Job No. 190388

February 21, 2024

Re: Response to:
Colorado Geological Survey, comments dated November 27, 2023
El Paso County Planning and Community Development, comments received Jan. 25, 2024
Esteban Subdivision
EL Paso County, Colorado

FIG No. 32

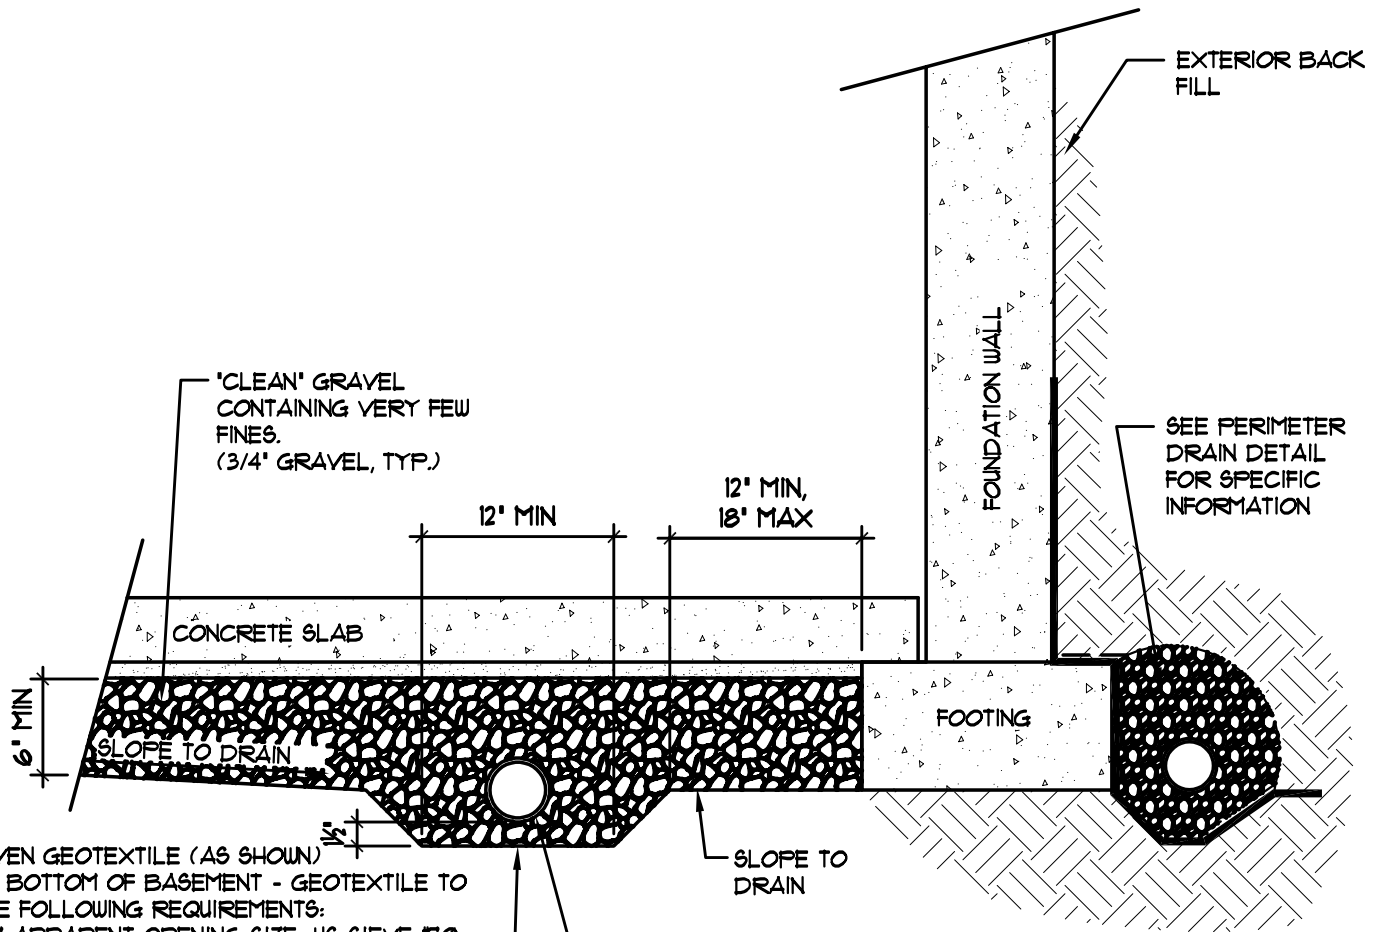
... to prevent the intrusion of water into areas below grade. A typical detail is shown in Figure 32.

State that the groundwater district has requirements regarding removal of groundwater

A statement has been added to our revised report.
